From: Paul Cann <Paul.Cann@arun.gov.uk>
Sent: 10 March 2022 13:32
To: Planning.Responses <Planning.Responses@arun.gov.uk>
Cc: Kevin Brook [REDACTED]
Subject: RE: Notification of an Environmental Statement M/16/22/PL

Application No: M/16/22/PL

Site Address: Land South of Grevatts Lane/A259 Climping

Description of Works: Laying out of an 18 hole 72 par golf course, a 9 hole golf course, practice greens and a driving range including a buggy compound; the formation of a new access onto the A259; construction of a club house with associated golf club facilities; the construction of a maintenance building and external area of hardstanding; the laying of parking, new roads and paths; new landscape planting; surface water drainage basins and water storage resevoirs; and other earth works and infrastructure. This application also lies within the parishes of Climping and Yapton, is a Departure from the Development Plan and affects a Public Right of Way. This application is subject to an Environmental Statement.

Figure 5: Flood mapping (Source: Client)

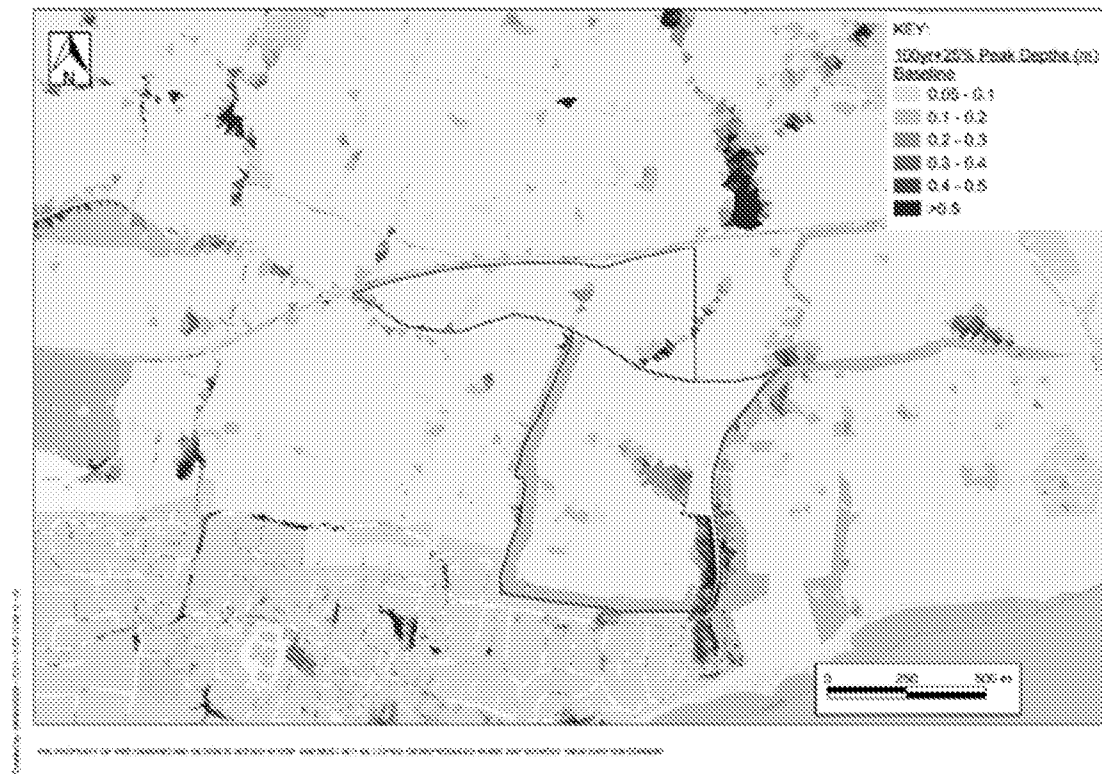
Since a majority of the site is within flood zone 2/3 based upon current Environment Agency (EA) mapping, then the EA should be consulted. It is noted that subsequent hydraulic modelling has been undertaken by the applicant and this will form part of the discussions with the EA.

The surface water flood maps show numerous low lying areas on the site, it is important that any of these areas that lie adjacent to watercourses or have any form of connectivity with watercourses are preserved in terms of extent and level, since they are likely to provide storage when the capacity of the watercourses are exceeded. If it is not possible to retain them in their present form, then they will need to be compensated for.

Figure 8: Illustrative Golf Plan (Source: Client)

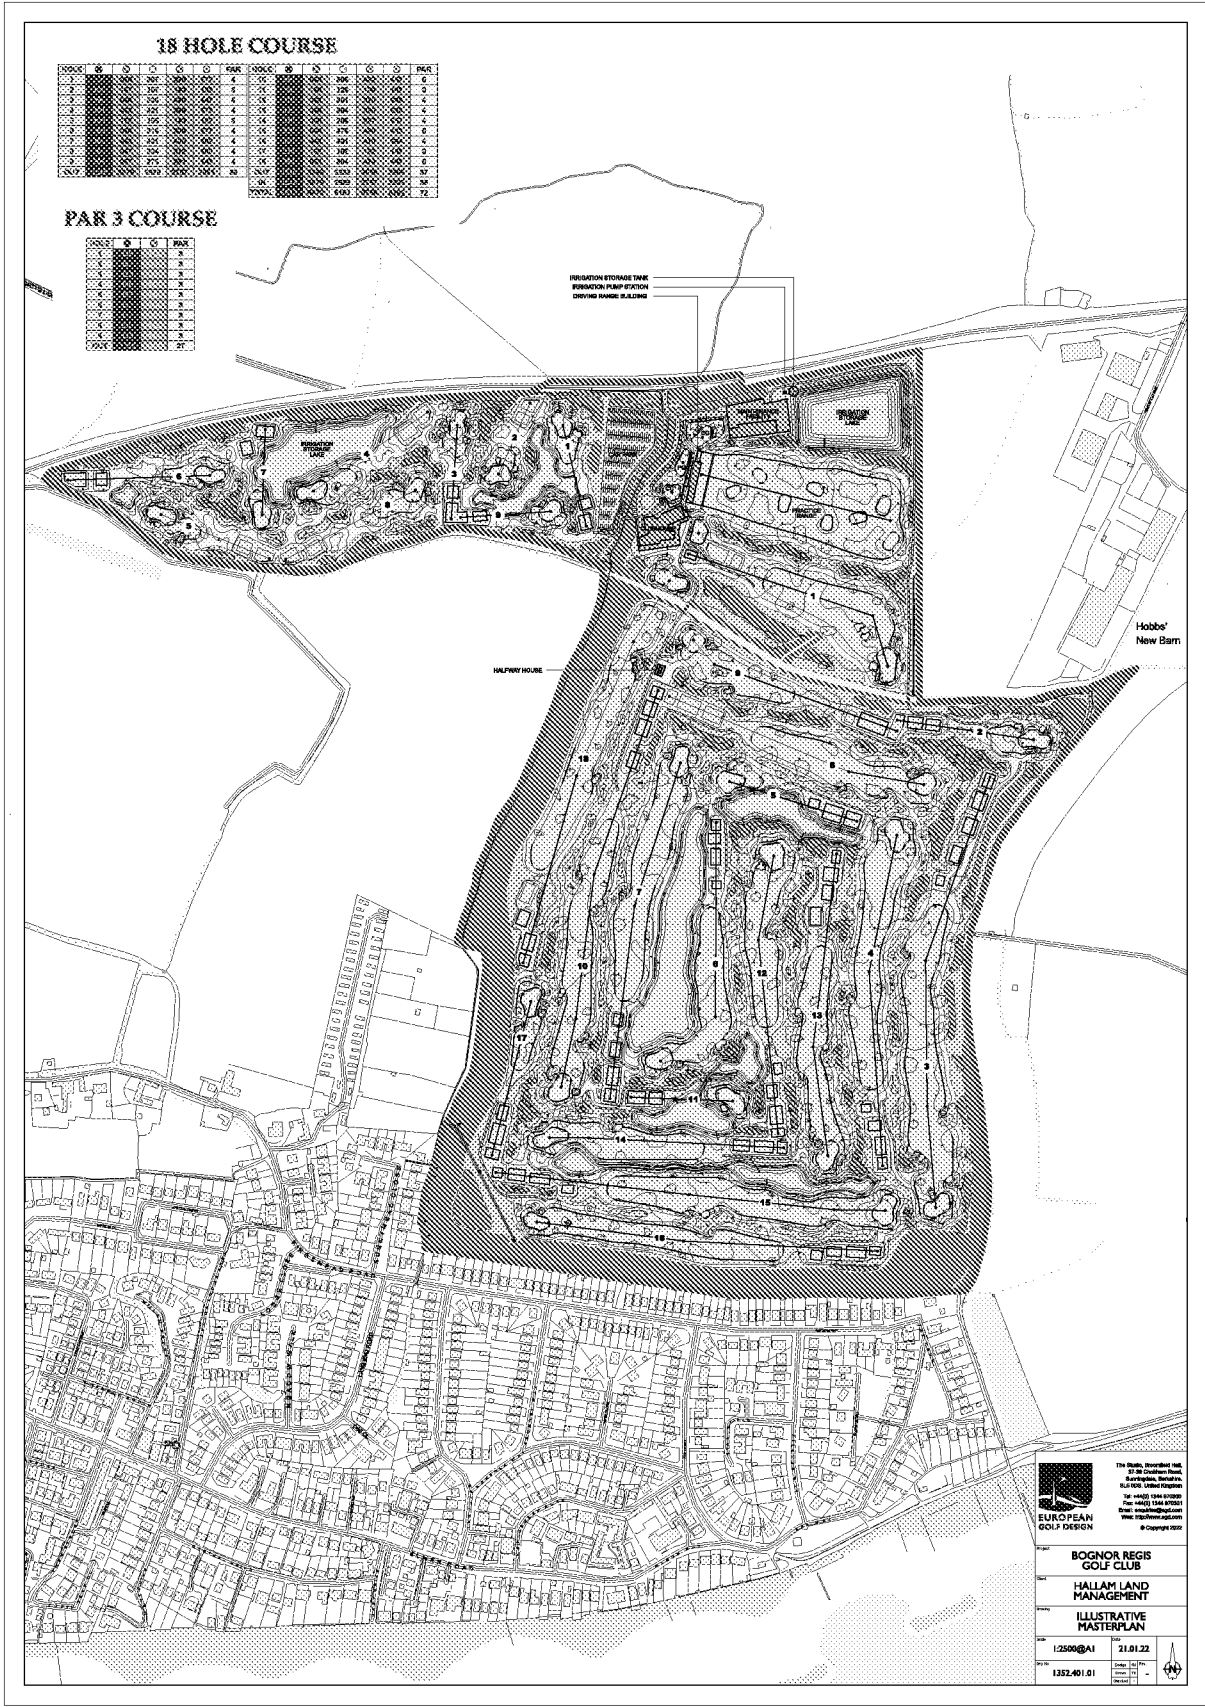
2. Numerous 'ordinary' watercourses are contained within the site or on the boundaries. All watercourses need to be suitably accommodated, ensuring a 3m buffer both sides for maintenance access and to ensure compliance with hour land drainage byelaws. Excessive culverting will be resisted. Examples are across the fairway of hole no.1 and to the north west of the club house. However, there also appears to be an alternative proposal shown for the watercourse crossing hole no.1 fairway, which involves it being diverted - this would be the preference.

3. A proposed watercourse diversion is noted just east of the proposed access onto the A259. Land Drainage Consent will be required for this work and any other non-maintenance works associated with 'ordinary' watercourses.
